Our Ref: WA/4/19/HH

**Town & Country Planning Act 1990 (as amended)
Town & country Planning (Development Management Procedure) (England) Order 2015
Application for Planning Permission for Works or Extension to a Dwelling**

Development Retrospective approval for variations to approved (ref.WA/22/07/) detached garage / store to form detached garage / annexe.

Location Ashogle Eastergate Lane Walberton

SECTION A:A

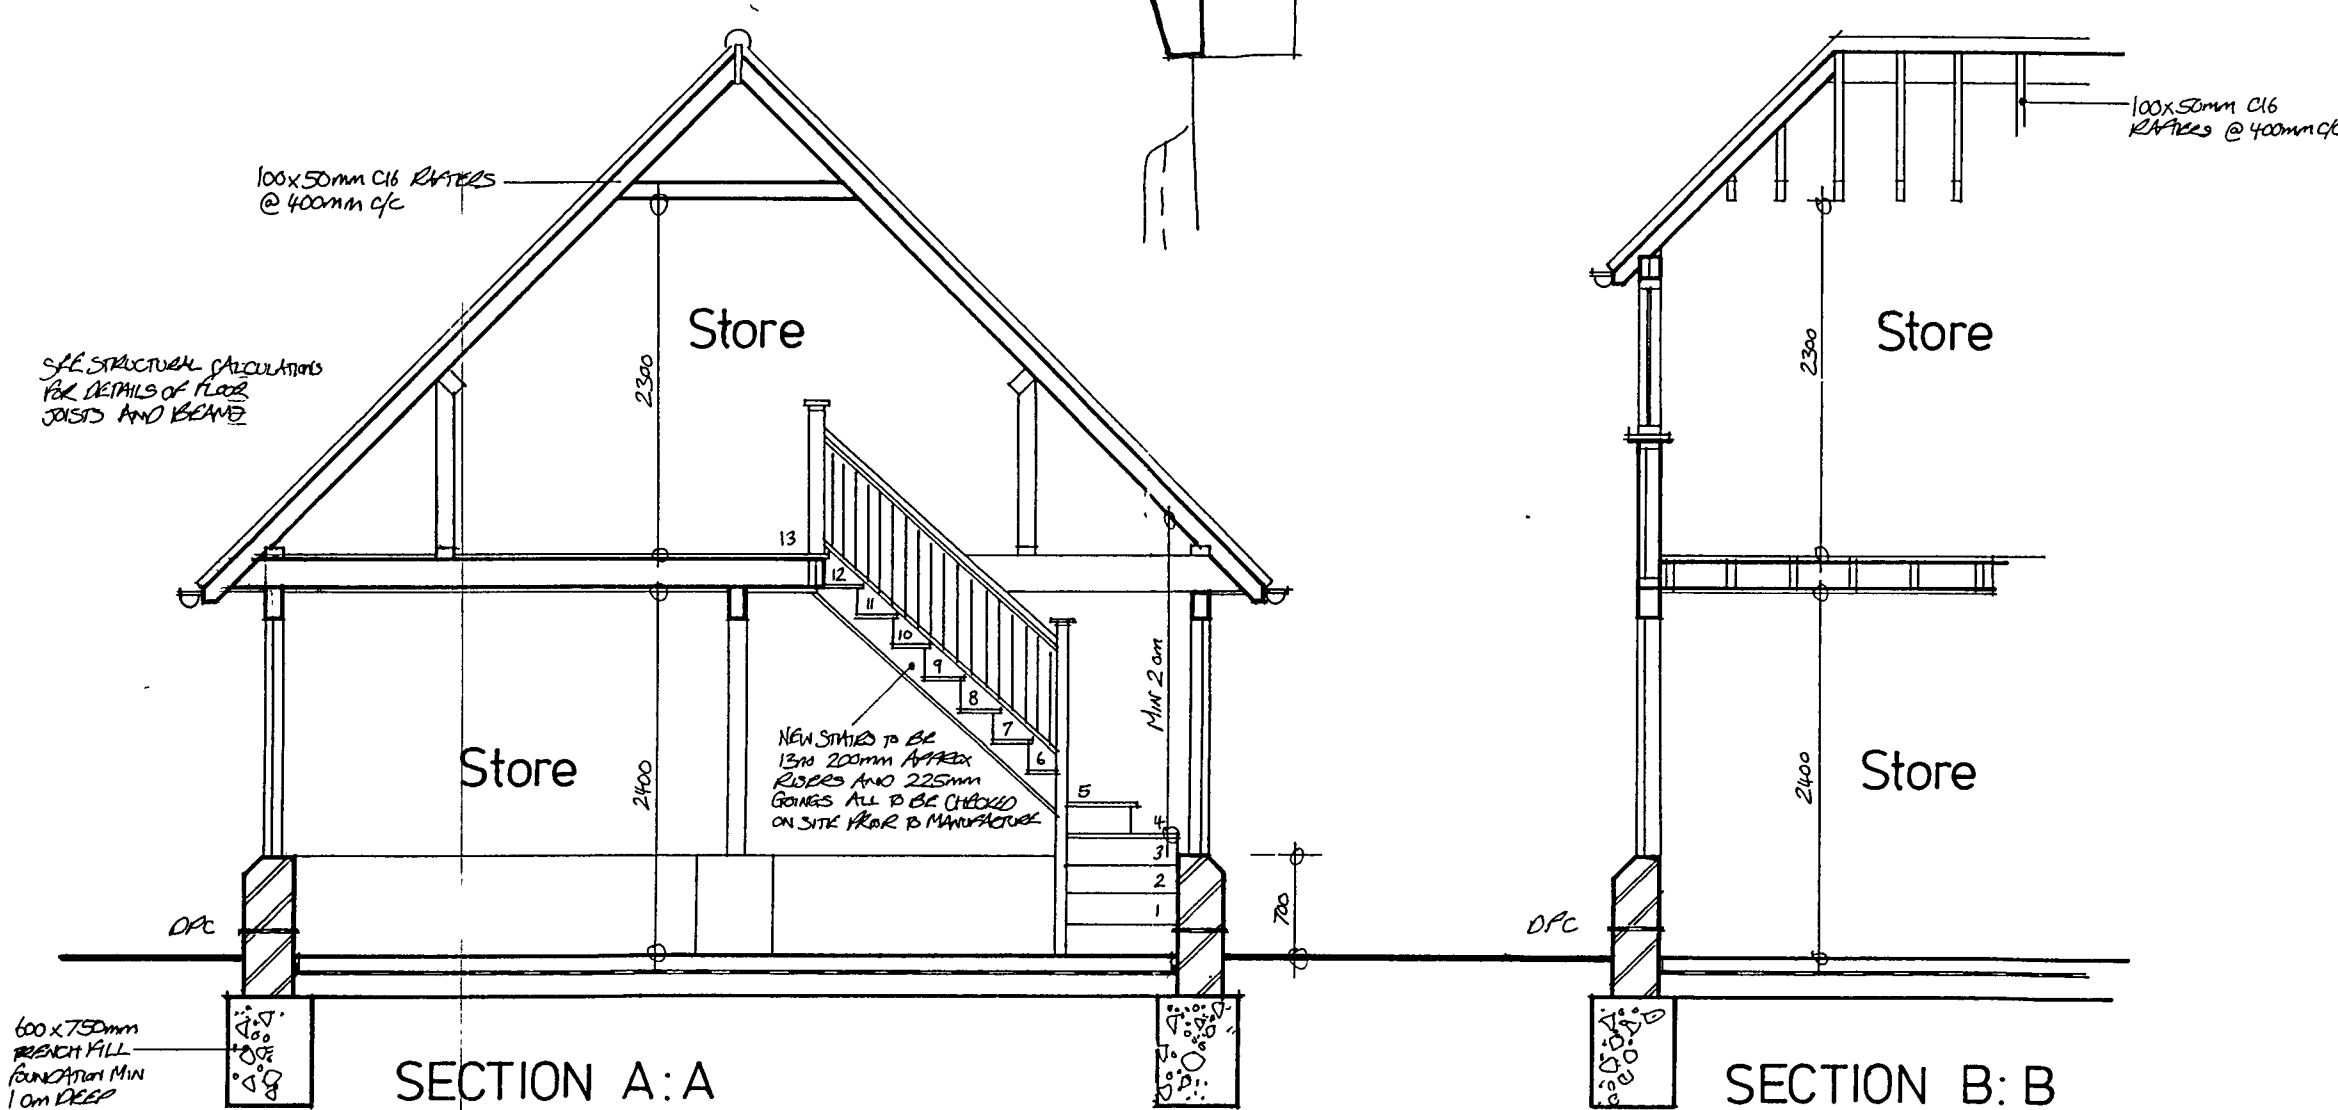
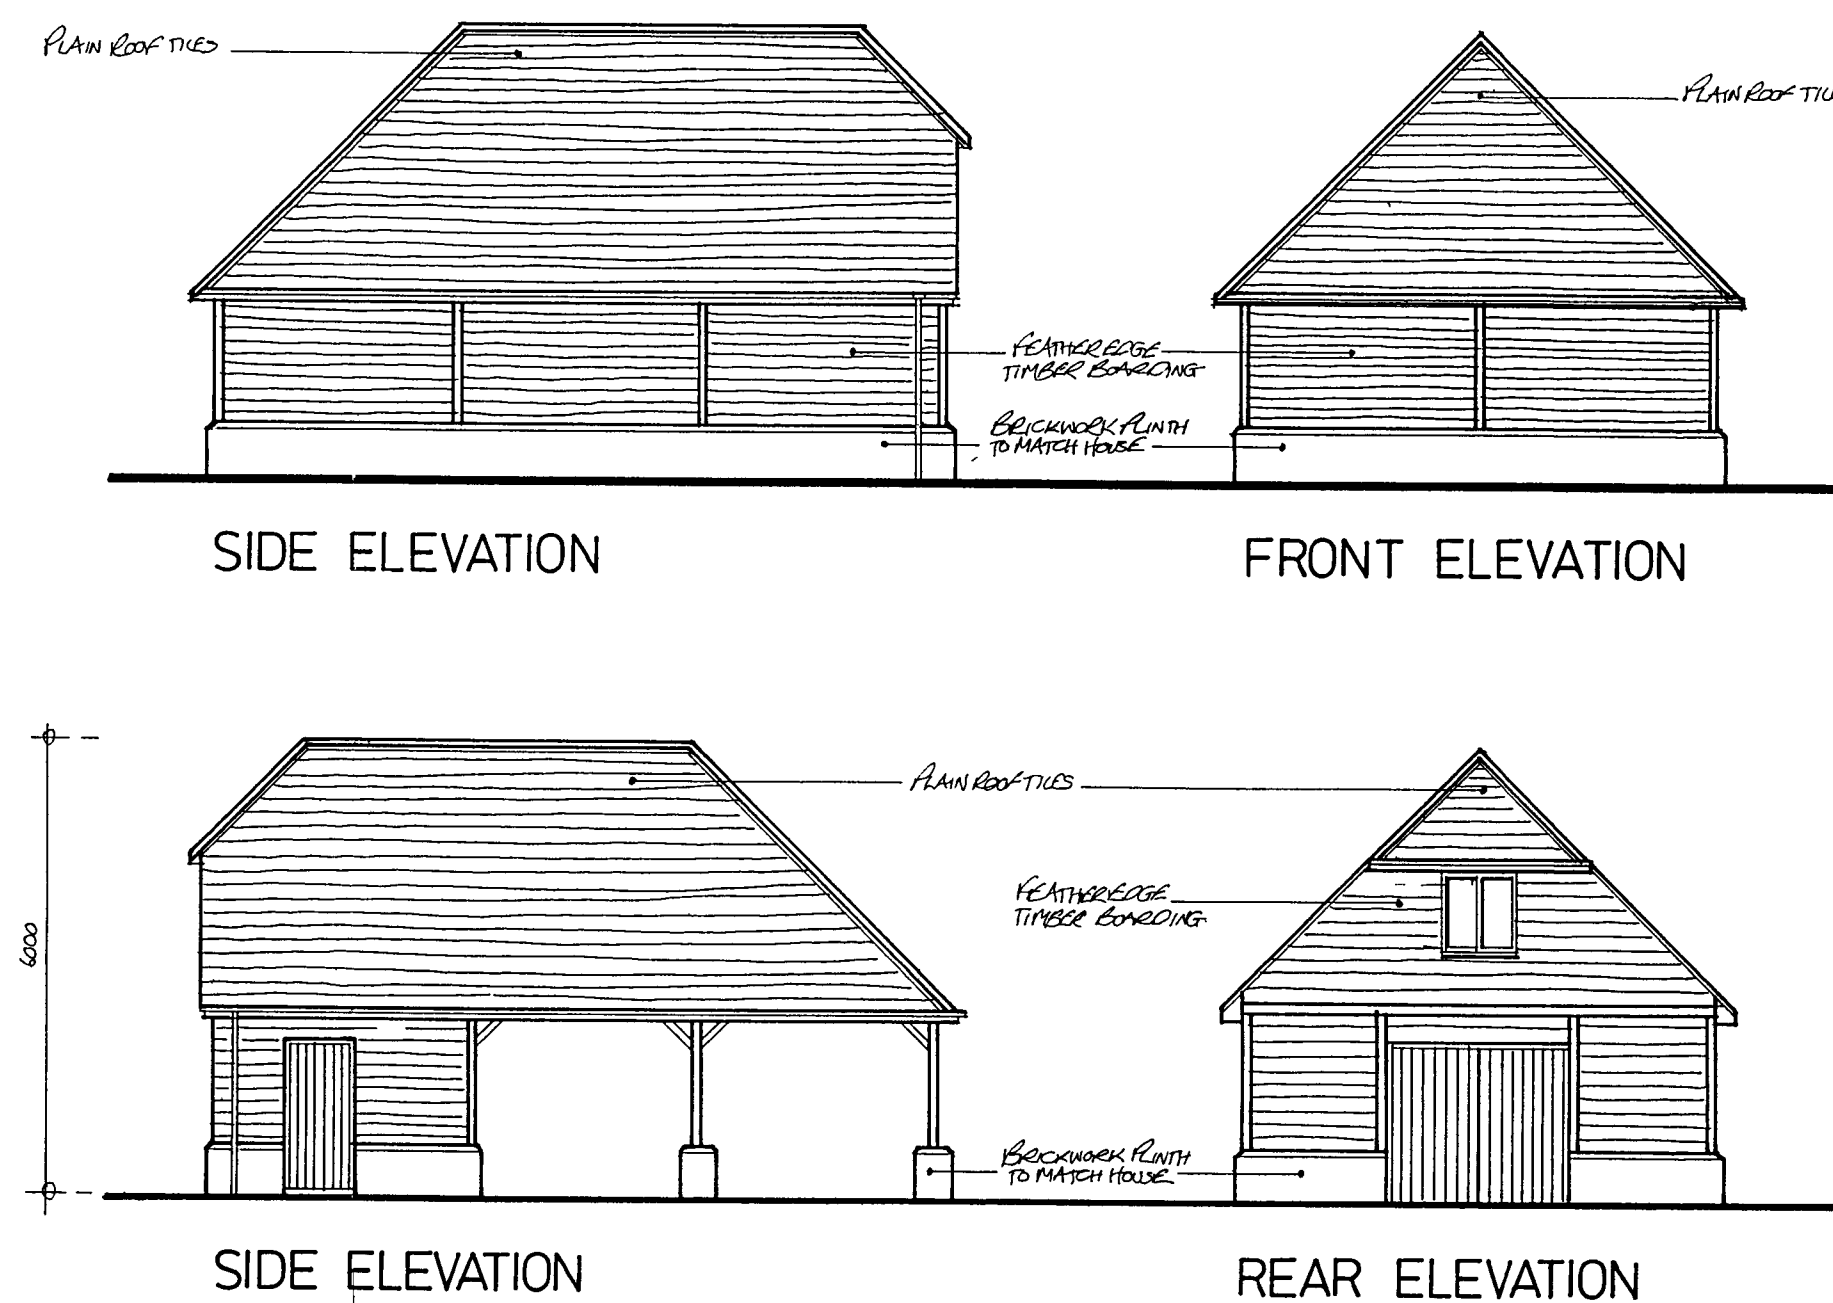
Approved Plan: Please label the approved plan as approved on the actual plan rather than as the saved file name.

Block Plan
Scale 1:200

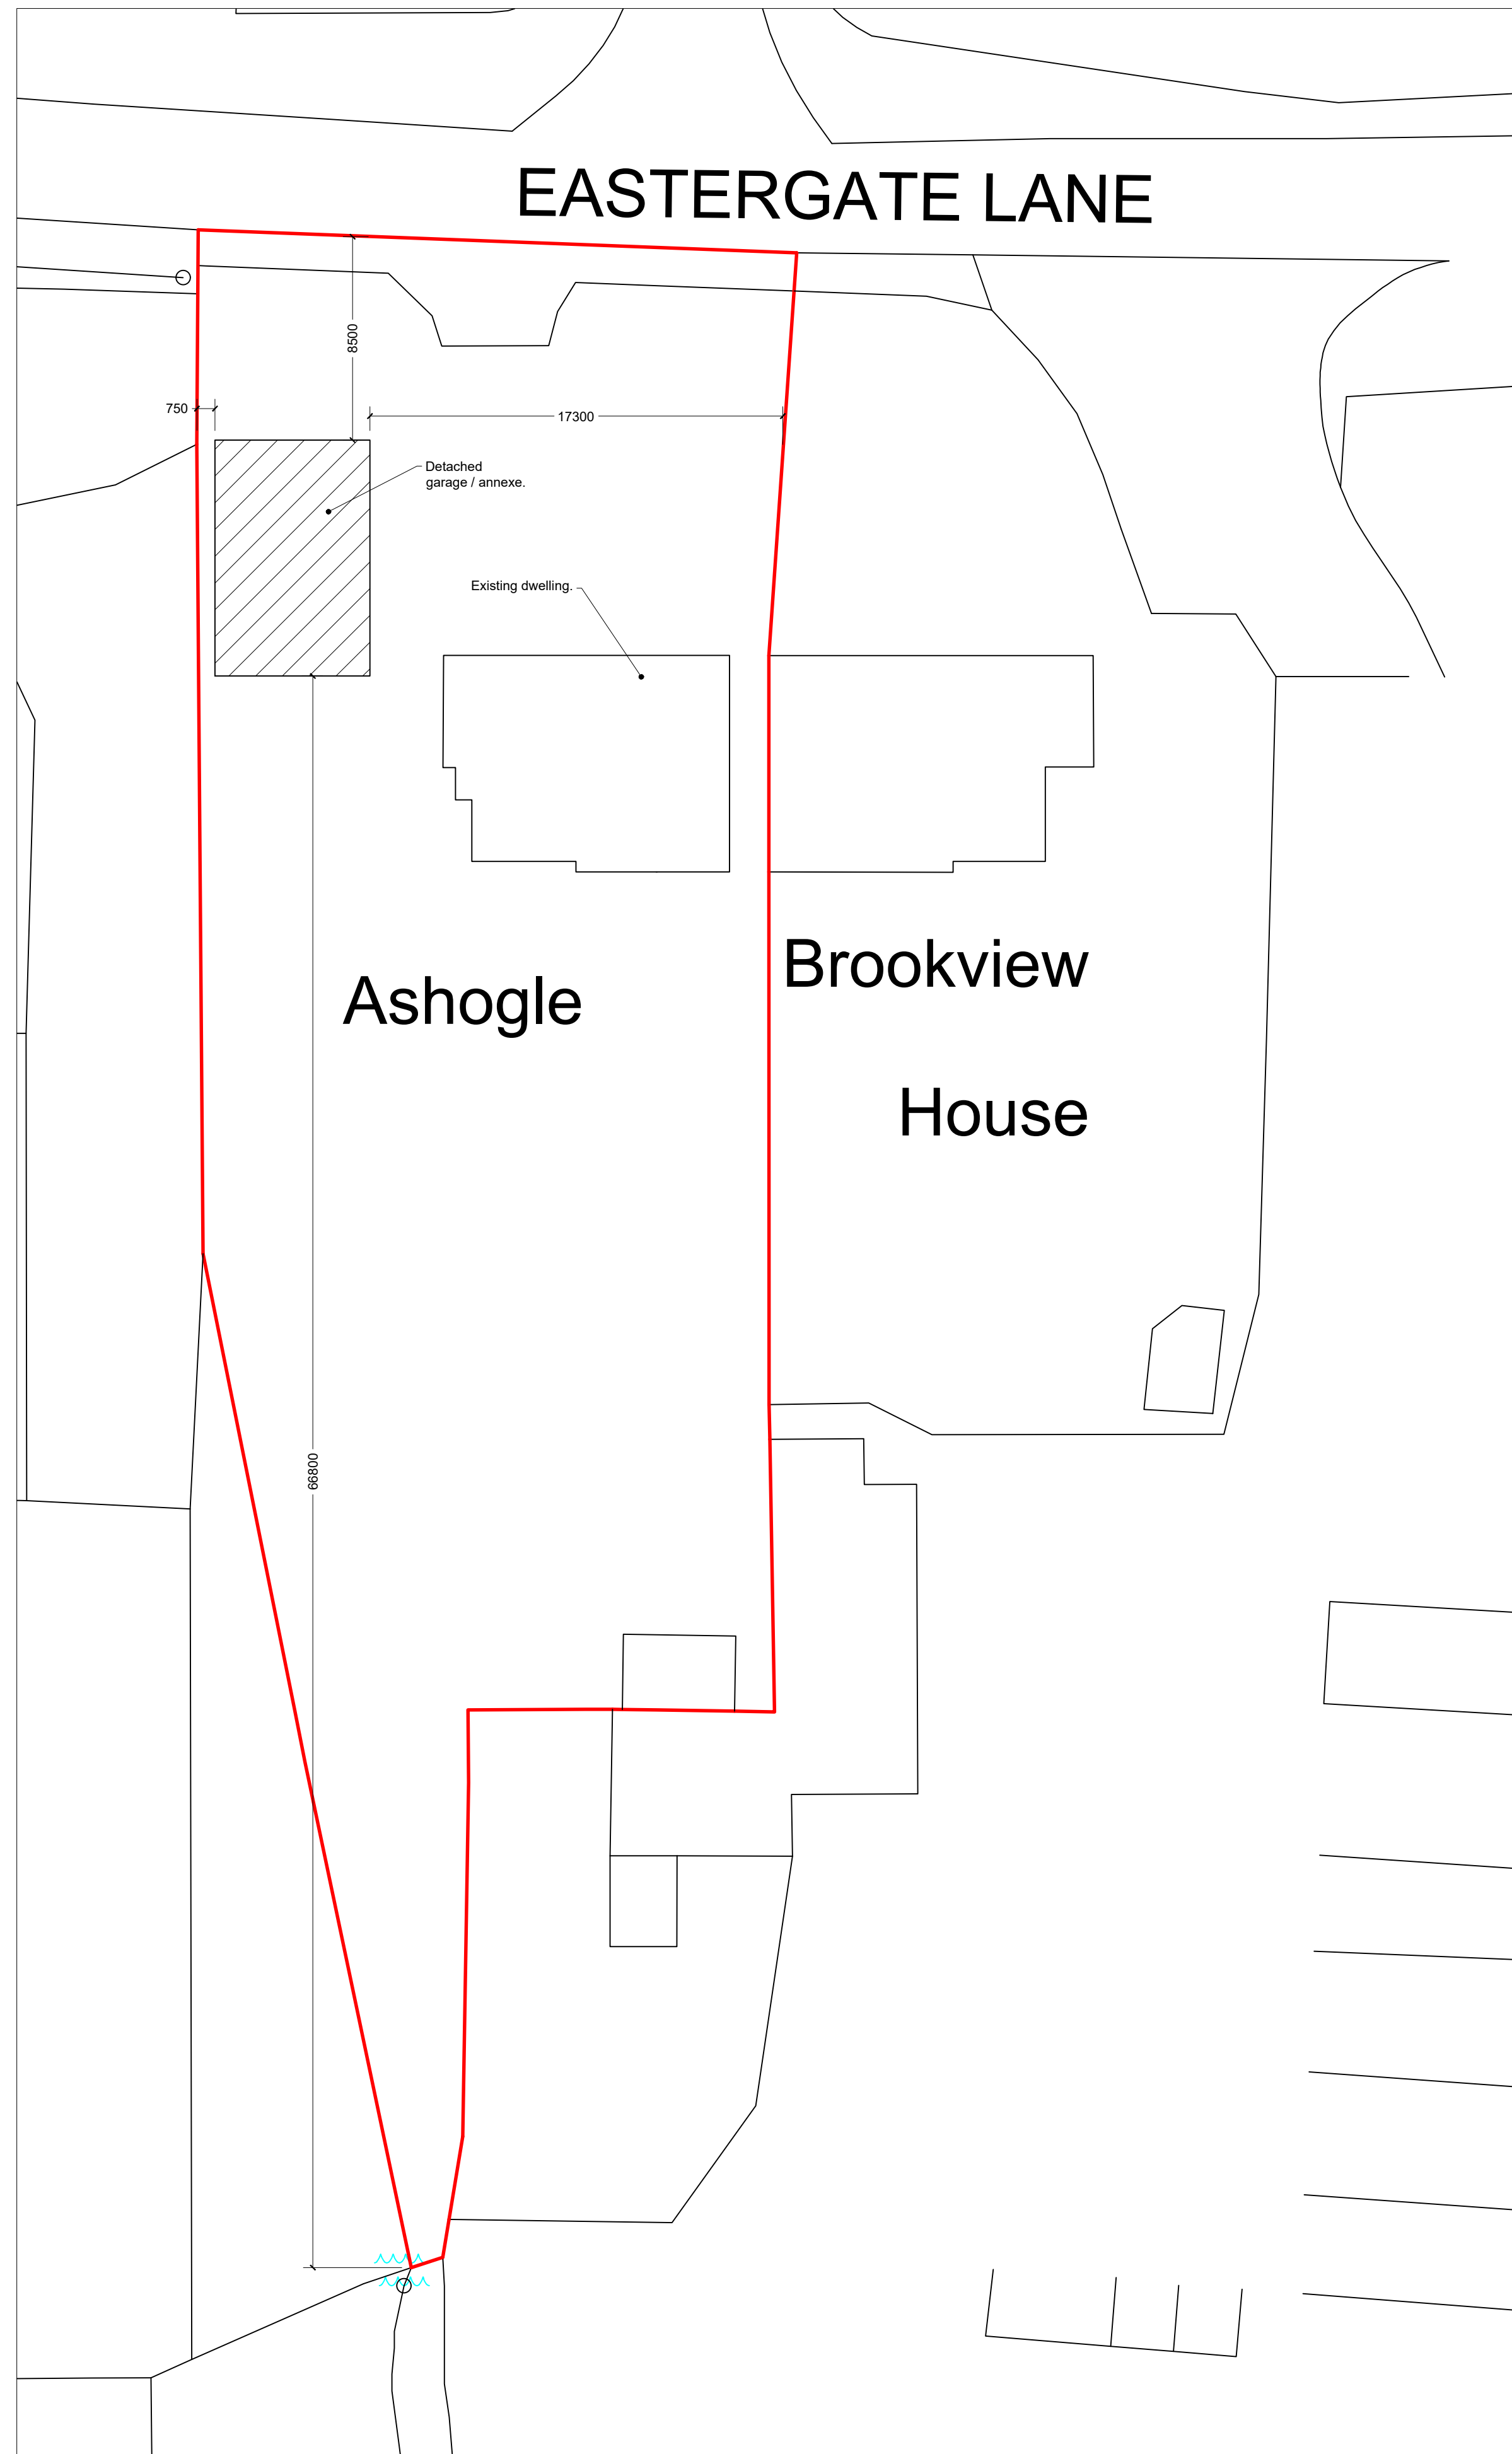
Block Plan

Please submit 1 electronic or 3 paper copies of a block/site plan which includes all dimensions from the outbuilding to the site boundaries. Further details of what must be included on the plan can be found in the National Validation Requirements.
